North Yorkshire County Council
and
Richmondshire District Council

A66 Northern Trans-Pennine Project

Summary of Relevant Representations
Submitted 2 September 2022

Examination Deadline 1 – 18th December 2022

Map Title
**Figure 2.8.7
Environmental Mitigation
Scheme: 09, Stephen Bank to Carkin Moor
Sheet 3 of 4**

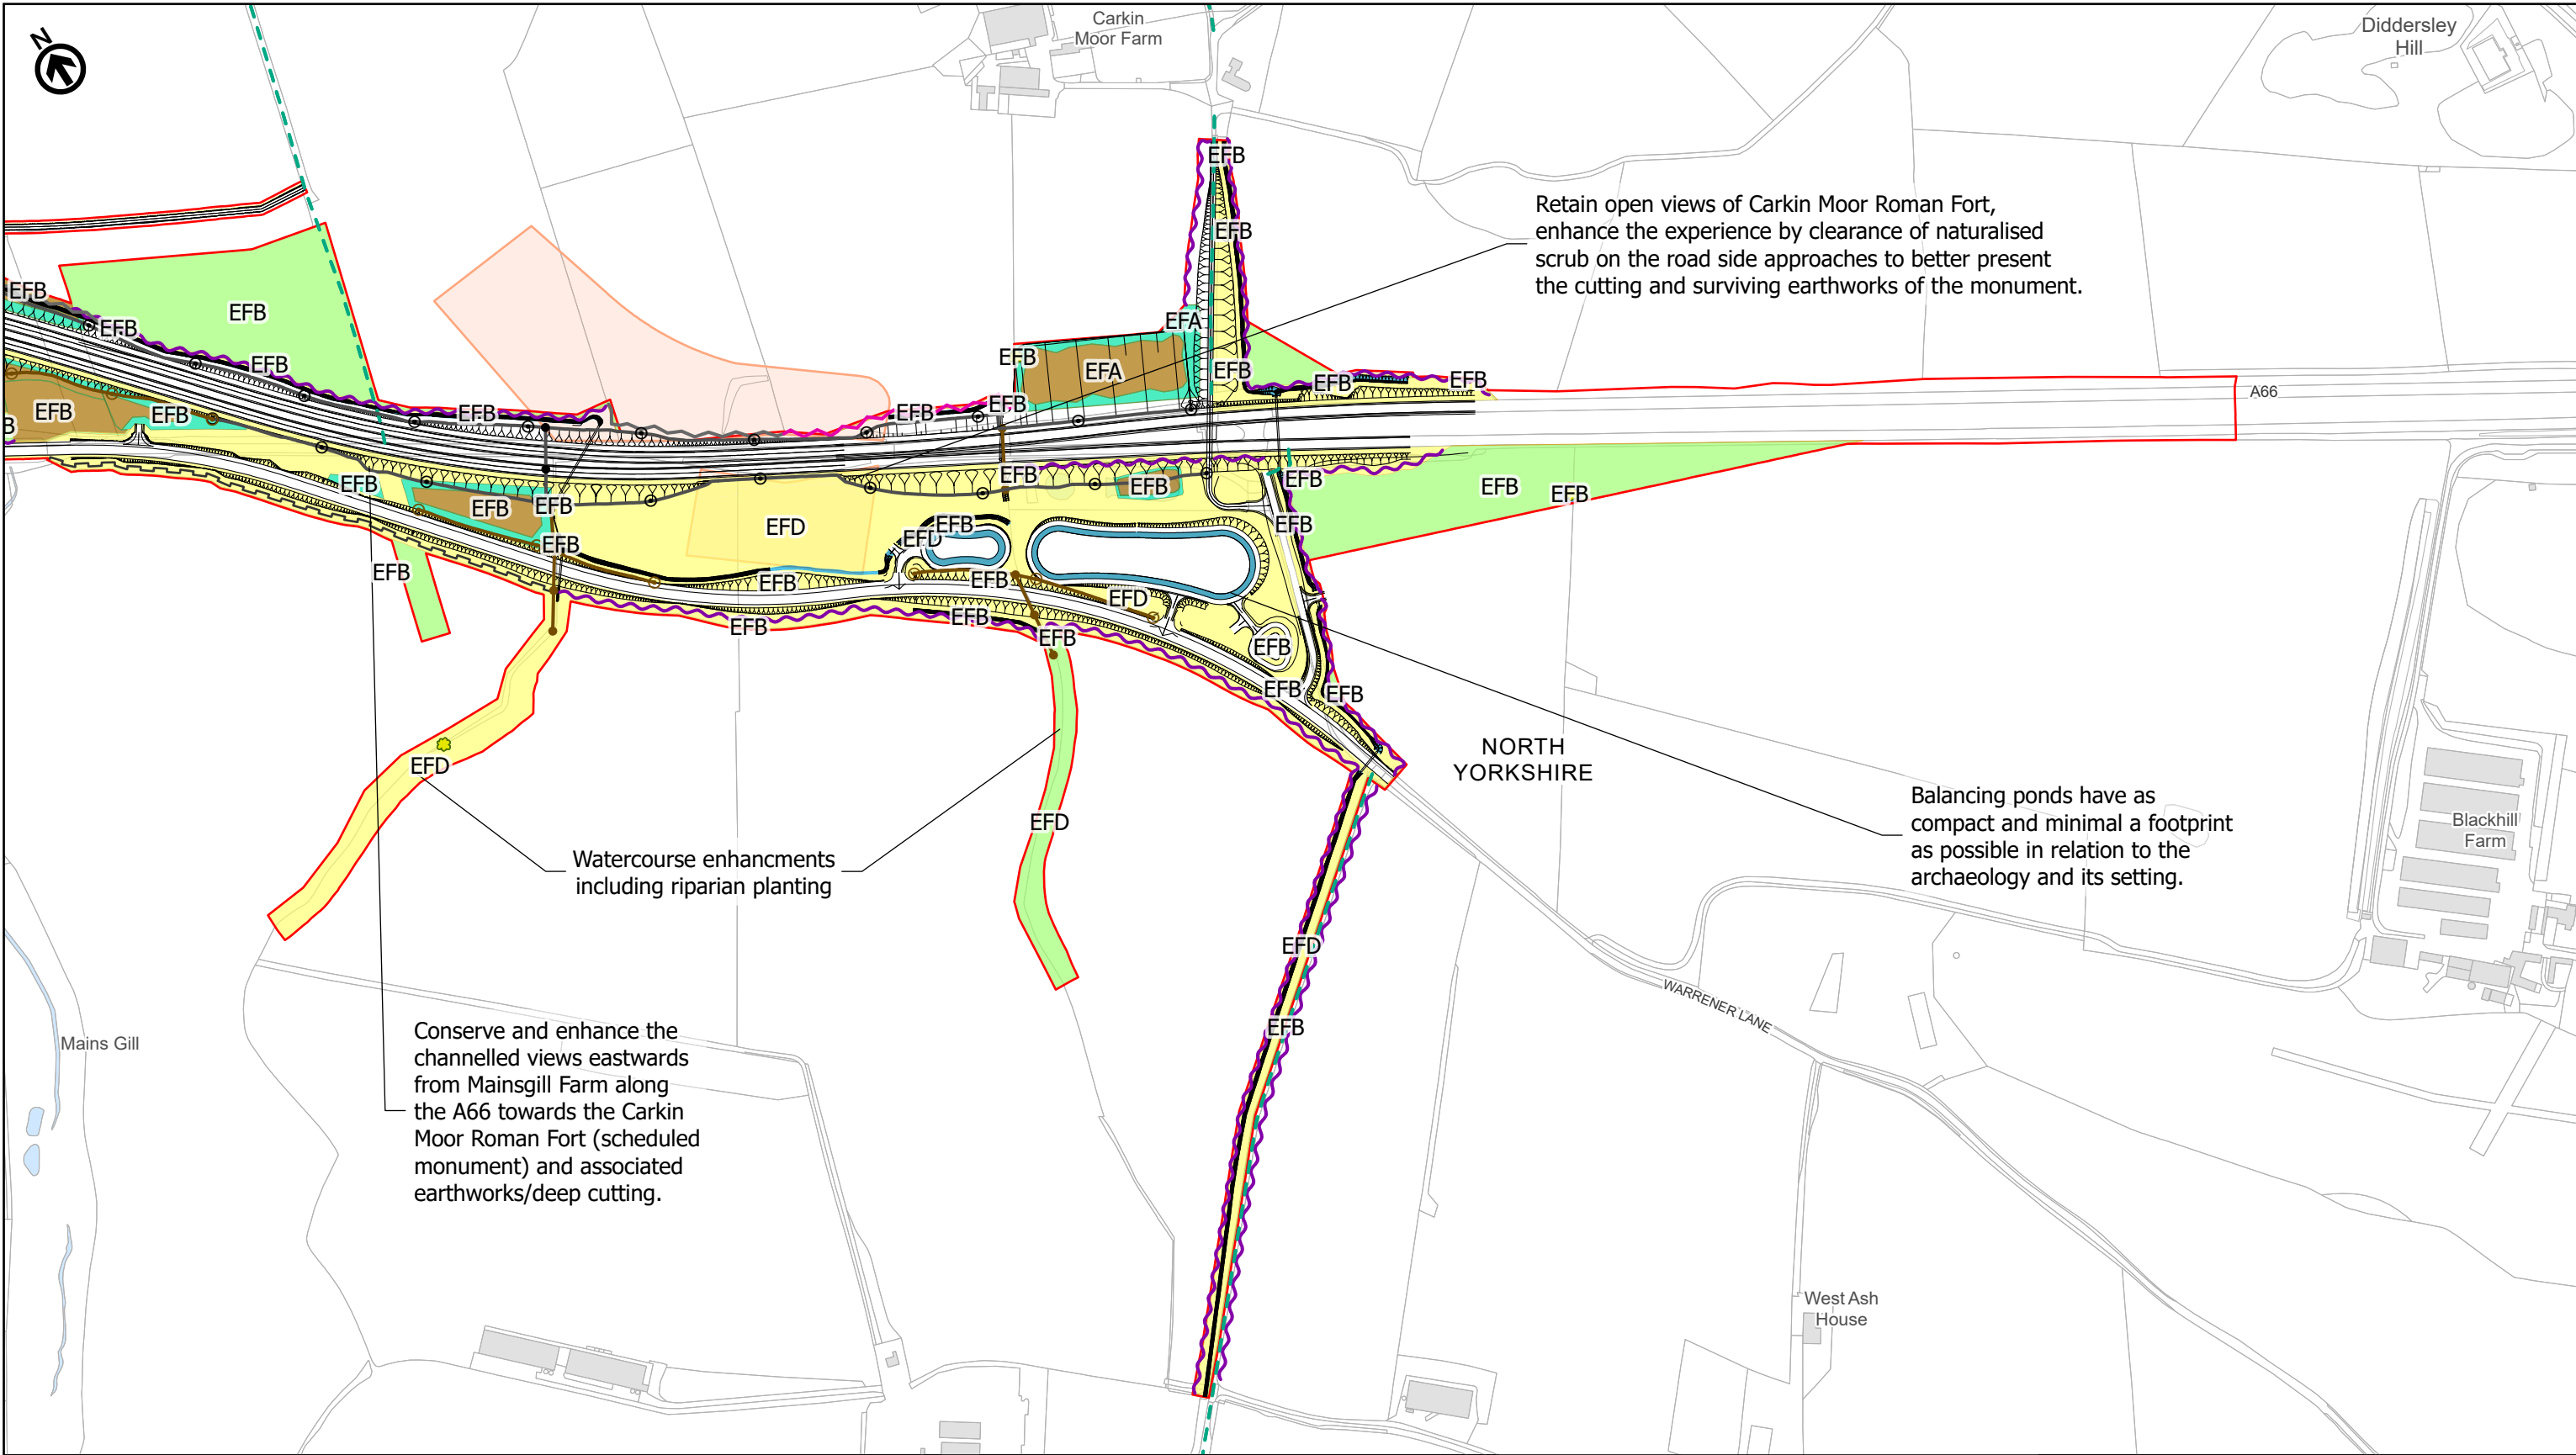
Scheme 09 sheet 3 Footpath 20.23/8/1 change **northwards** to **southwards**
